Re: Marist Catholic College North Shore
Application No.: SSD-10473

Response to Exhibition of Amended State Significant Development Application

**Figure 8: Proposed Miller Street extended streetscape elevation - north**

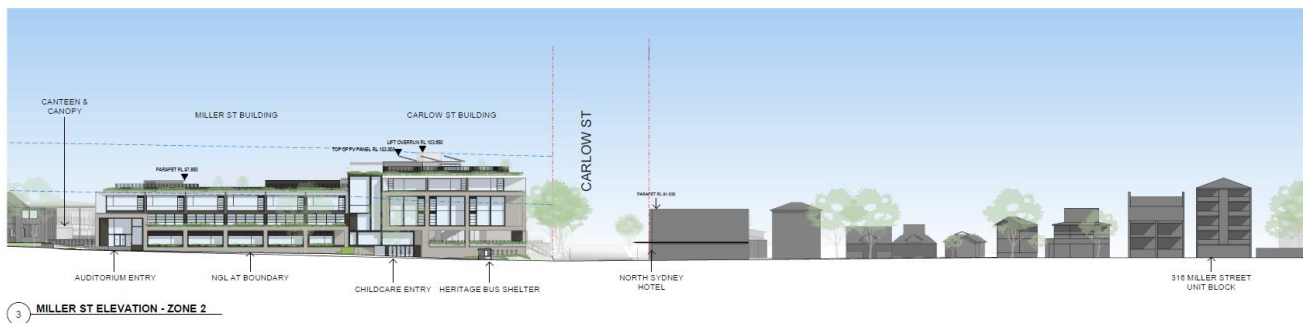
The Ethos Urban letter on Page 9 further notes *"While of greater height and bulk to the North Sydney Hotel, as is shown in Figure 7 and Figure 8, this is not considered to constitute a visually unacceptable relationship. The height difference will be read as approximately 1.5 storeys. As shown in Figure 8, it is noted that a similar height already exists in the Miller Street streetscape nearby and to the north of the site. The length of the Carlow Street building to Miller Street is also not considered to be visually excessive when read together with the North Sydney Hotel."* If this same argument is used in respect of the western section of the Carlow Street Building which is opposite/adjacent to the residential houses, the following conclusions must be reached which highlights the inappropriateness of a building of this bulk and mass being continued into the residential zone of Carlow Street:

- (i) There is a visually unacceptable relationship
 - (ii) The height difference will be read as 3 storeys (including the rooftop recreation space)
 - (iii) There are no similar height buildings in the residential zone of Carlow Street. It is noted that all new developments on the adjacent/southern side of Carlow Street are zoned R# Medium Density and restricted to 2 storeys.

**Figure 9: Proposed Carlow Street extended streetscape elevation**

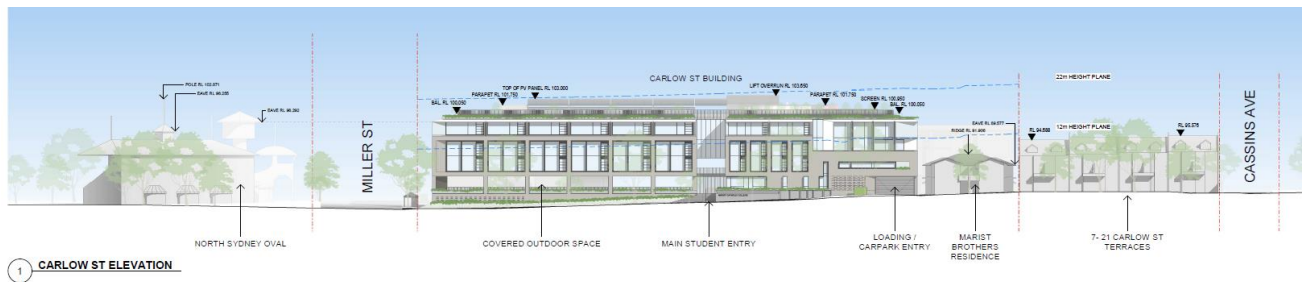
2. Currently all the properties with a frontage to Carlow Street are designated R2 Low Density Residential or R3 Medium Density Residential, with both the school and the North Sydney Hotel having a Miller Street frontage. The residential properties in Carlow Street are characterised by single, and two-storey, detached and semi-detached dwellings, and the proposed development reorients the school frontage to Carlow Street and in doing so, makes no concession to maintaining the residential appearance of the street. If approved, this development will result in the undue imposition of bulk and scale relative to surrounding existing low scale, one to two storey residential developments, and as viewed from the public domain. The proposed building typology, density and scale is incongruous with the low/medium density residential character of Carlow Street which it will now have as its frontage.

As the surrounding sites on Carlow Street will continue to be zoned for low/medium density residential development and subject to the development guidelines of the North Sydney Local Environmental Plan 2013 and "Conservation Area Study for the Holtermann Estate Conservation Area 1998", any future development on the Marist College site should take cognizance of the surrounding area. The current structures on the site sit below the existing tree line however, the scale of the proposed development means it cannot be fully mitigated by the existing street trees or proposed landscaping and this is shown in the plans submitted.

residential component of Carlow Street commences and continues until West Street, with all houses located on the northern side of Carlow Street having a consistent heritage frontage - not just those located in the central/western ends of the street as stated in the Ethos Urban letter. Therefore, the continuation of the proposed building height opposite the residential houses located at the eastern end of Carlow Street will result in significant visual and heritage impact to those properties.

4. The lack of acknowledgment in the proposed design to the residential and heritage zone of Carlow Street is highlighted by the reduction in building setback as the building proceeds along Carlow Street. At the corner of Miller and Carlow Streets the setback is 6,300mm due to its substantial height but this is incrementally reduced to 4,400mm as the building progresses to its western end on Carlow Street – where it is opposite and adjacent to residential properties all of which have a significantly smaller footprint.

EDUCATIONAL LEARNING PRECINCT - BUILDING SECTIONS
1:600 SCALE

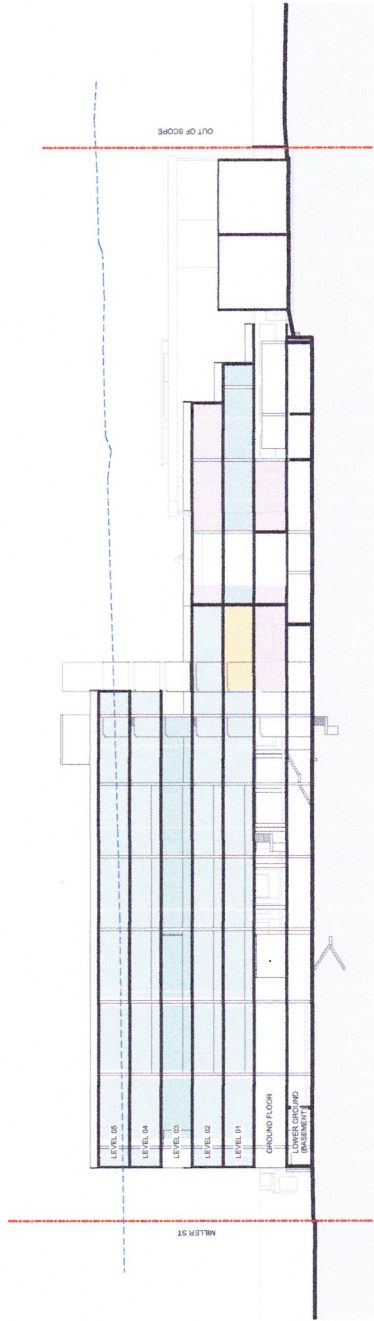
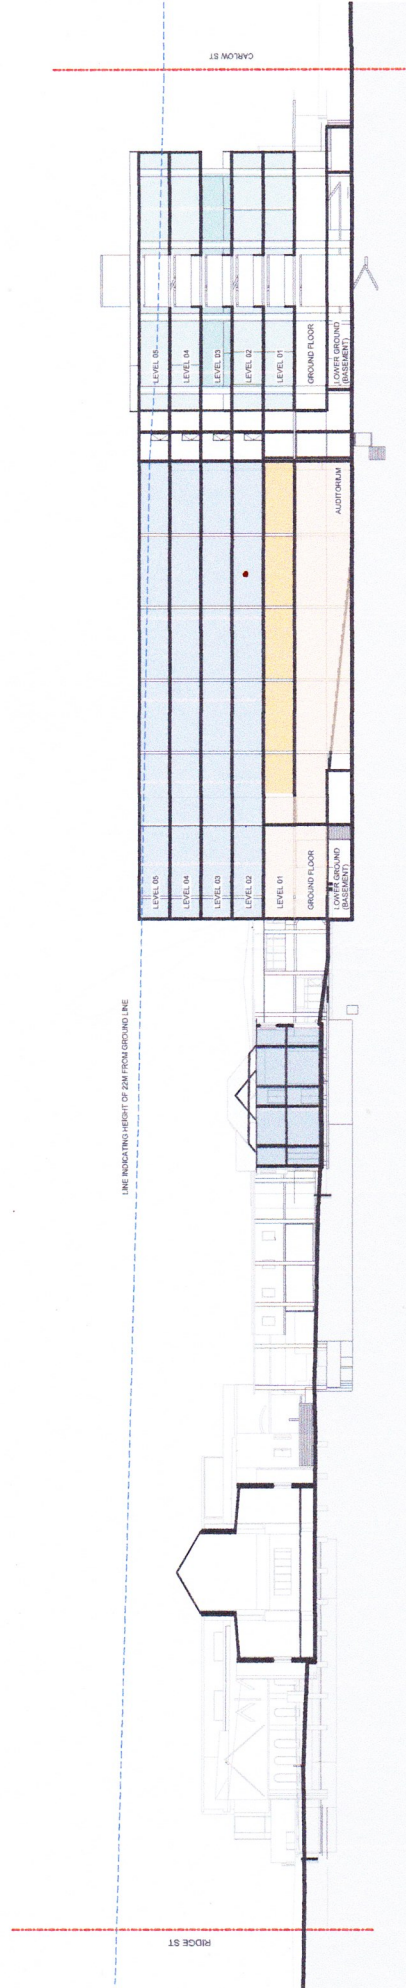
1. Our reading of the Carlow Street Building Sections contained in the original concept plan for the site, is that it was proposed that the building on the corner of Miller and Carlow Streets would be 5 levels above ground floor at the Miller Street corner and then reduce to 2 levels above ground floor where the building was (approximately) opposite the residential area of Carlow Street (west of Tucker Street). This reduction in height was also confirmed (in our reading of the concept plan) by the Ridge Street Building Section which showed that the western end of the Carlow Street would not be visible above the rooftop of the St Mary's Primary School located on Ridge Street.

(Refer attached Annexure A – Pages 16 and 17 of North Shore Education Precinct| School Masterplan Report)

The current plans, indicate the entire Carlow Street Building will now be 4 levels above ground with a rooftop recreation space, resulting in an overall increase in the building mass. As currently proposed, the building's frontage to Carlow Street at its western end will be ~20m (natural ground level). This is significantly higher than any other building in the residential area of Carlow Street and the maximum building height of 12 metres outlined in the North Sydney Local Environment Plan 2013 (Clause 4.3).

It is requested that the building mass be returned to the design outlined in the original concept plan which would provide more alignment with the surrounding residential properties.
